Mercer Island Dept of Construction and Land Use

Response to reviewer's intake comments:

Project : RKK Residence 2008-087 3406 72nd PI SE

SHEET NO. **A3.0**

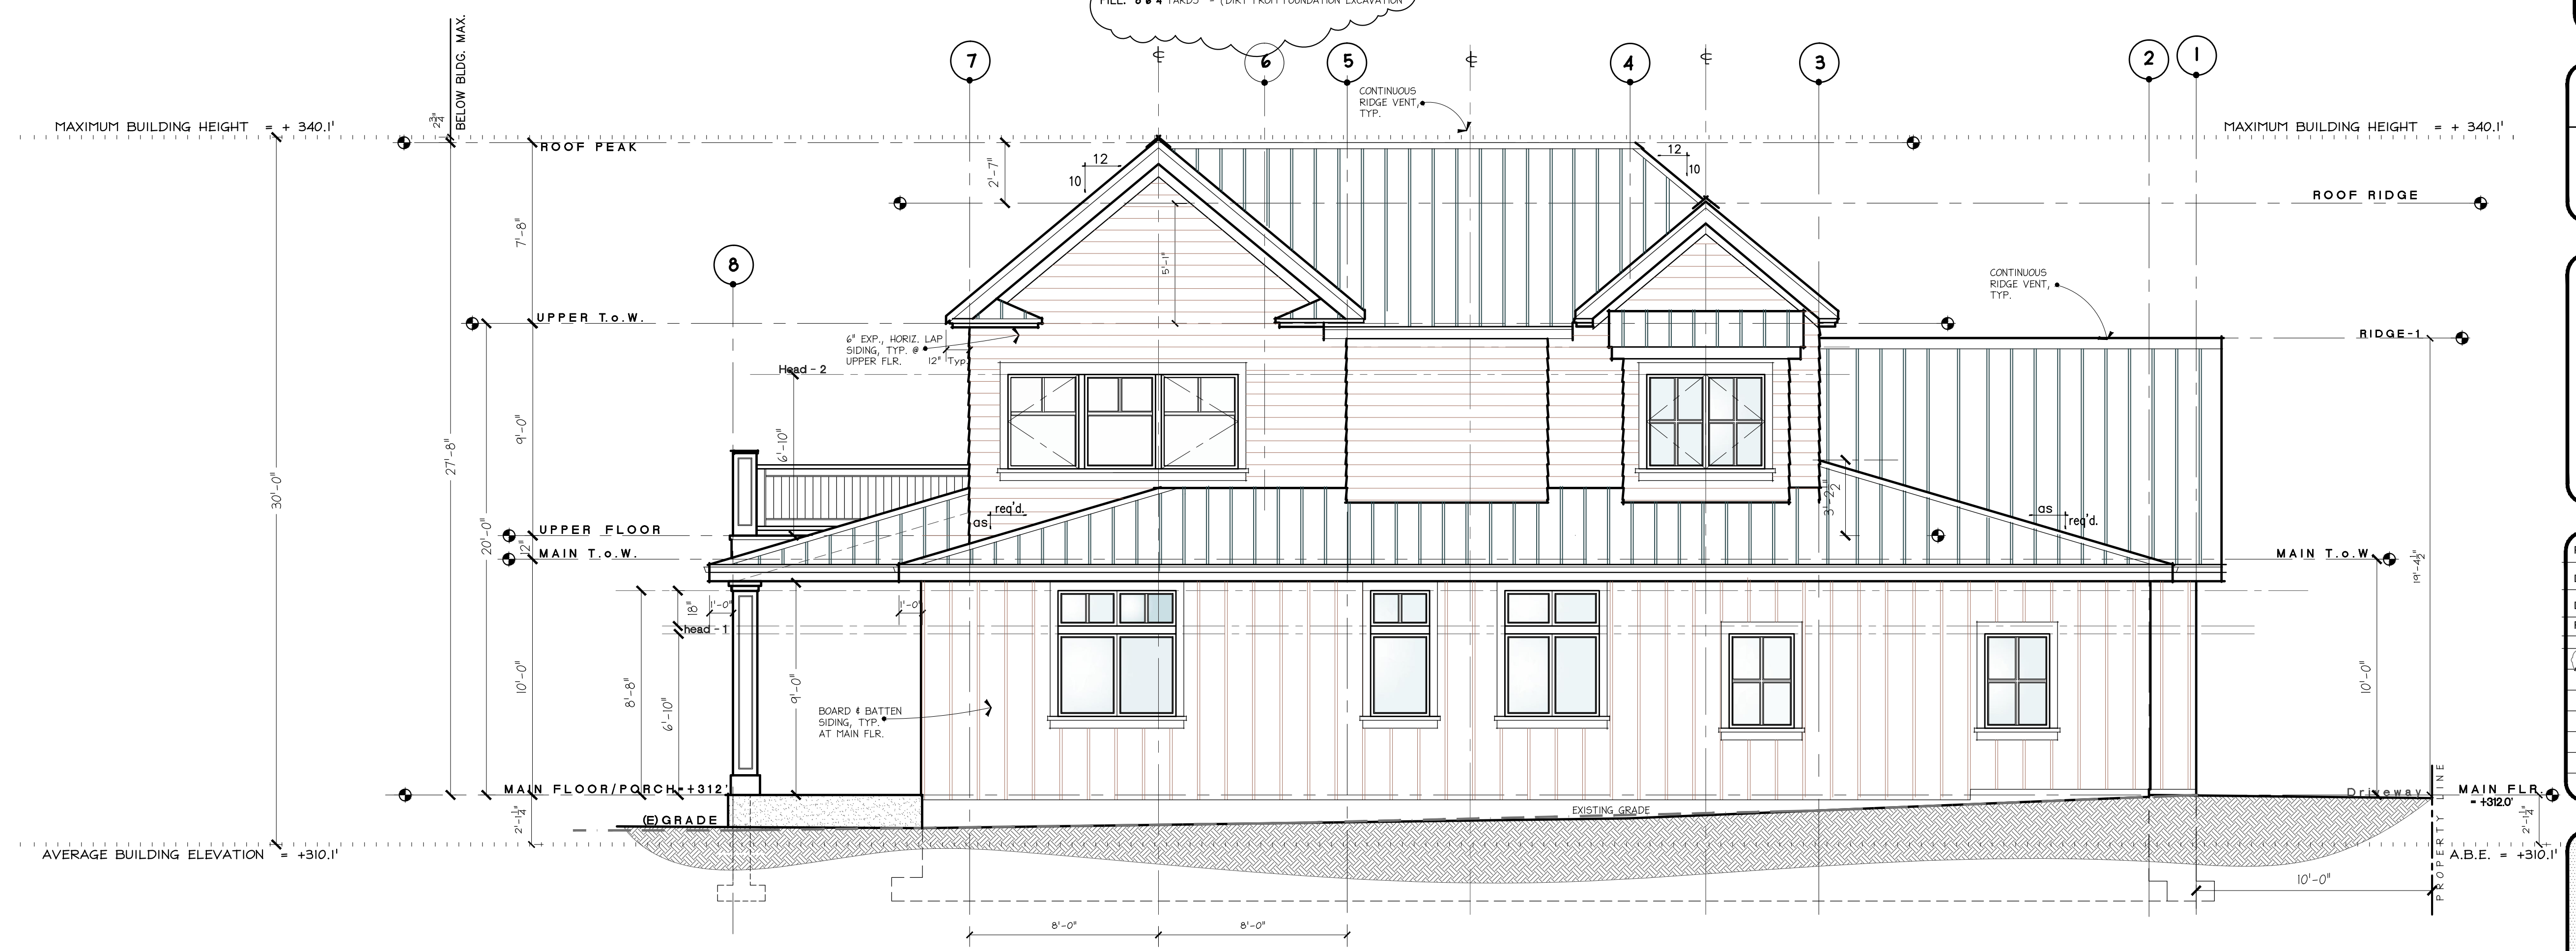
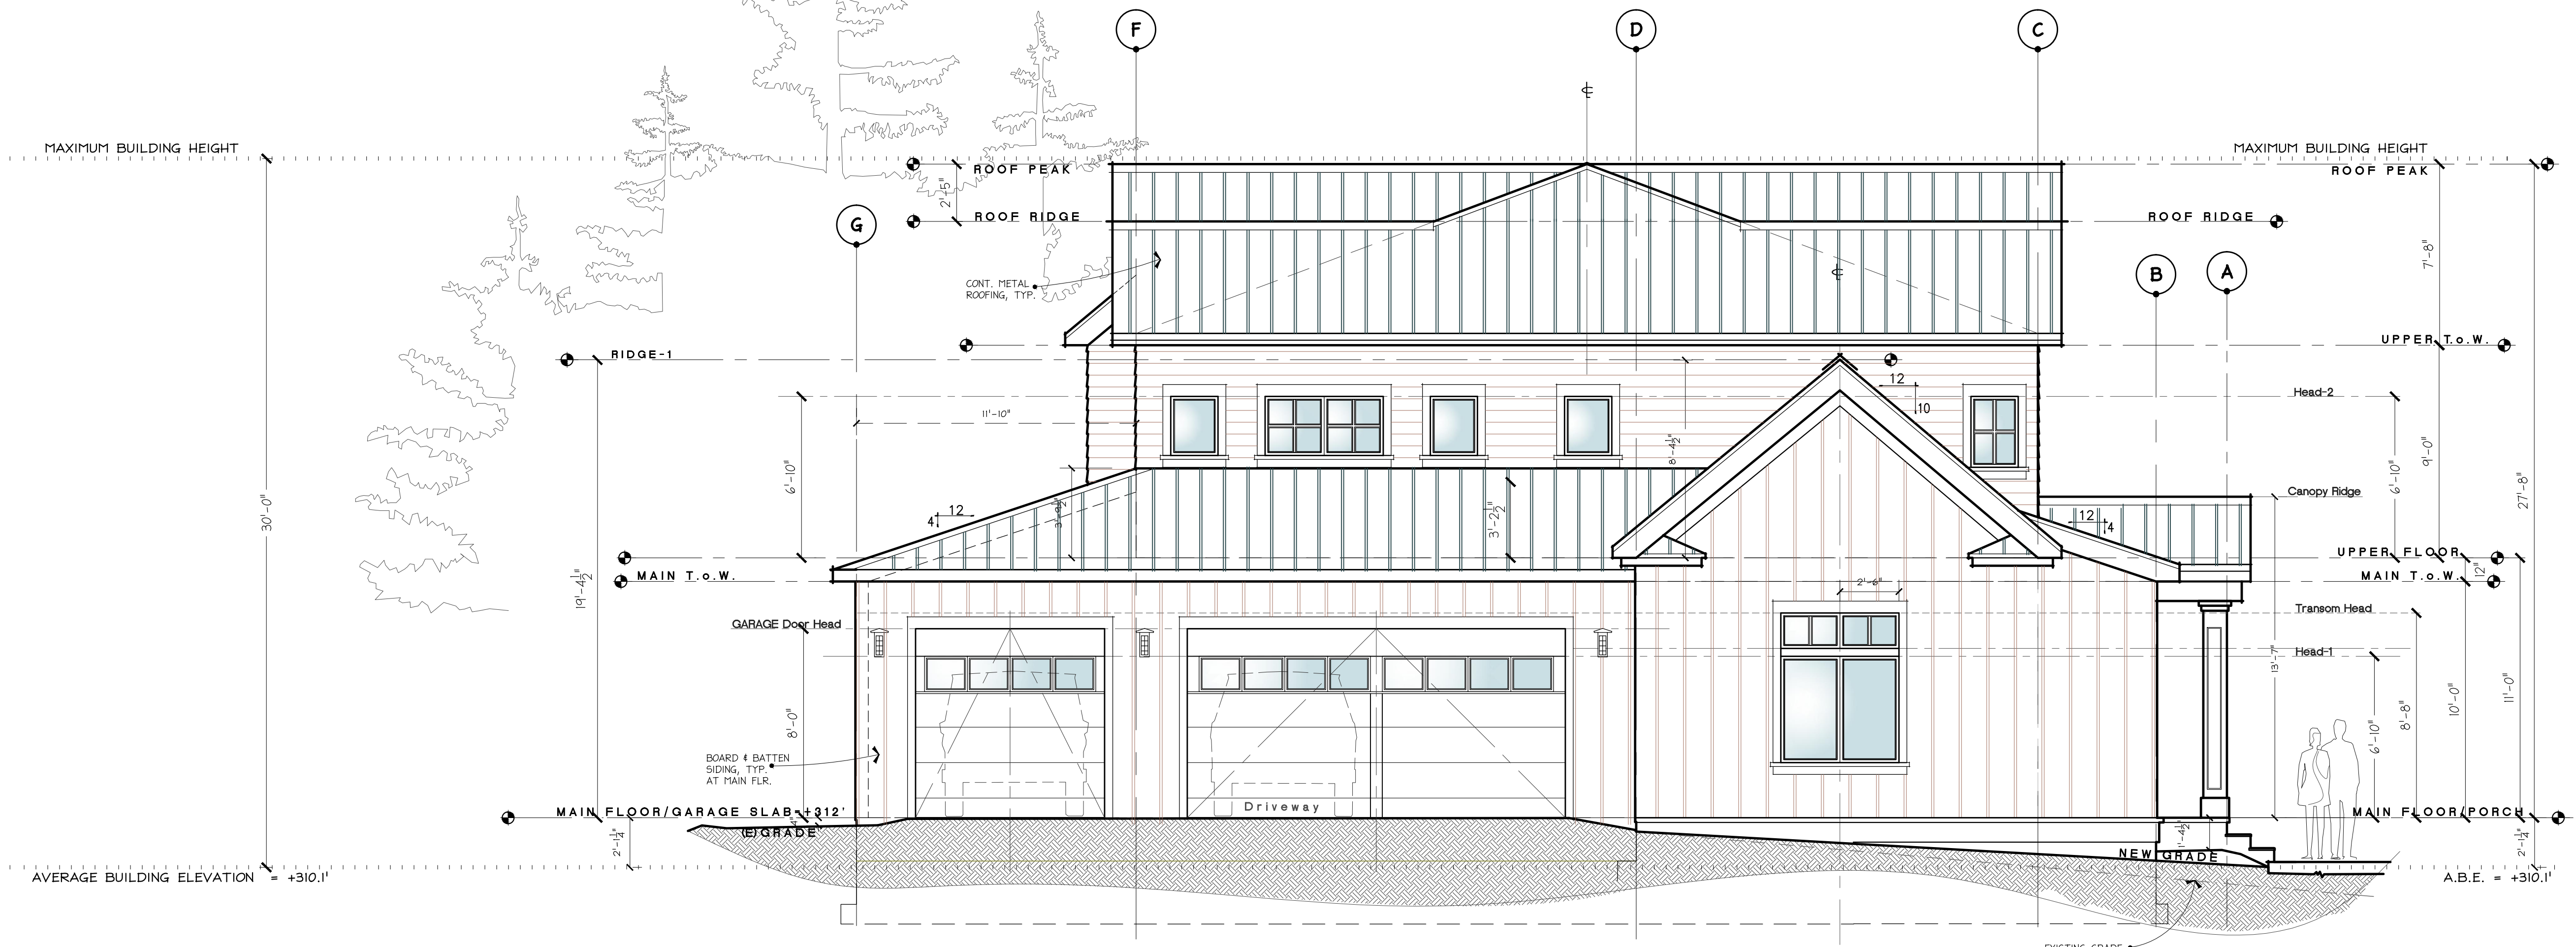
A3.0 Elevation: Maximum height downhill façade bubbled, grading cut and fill added
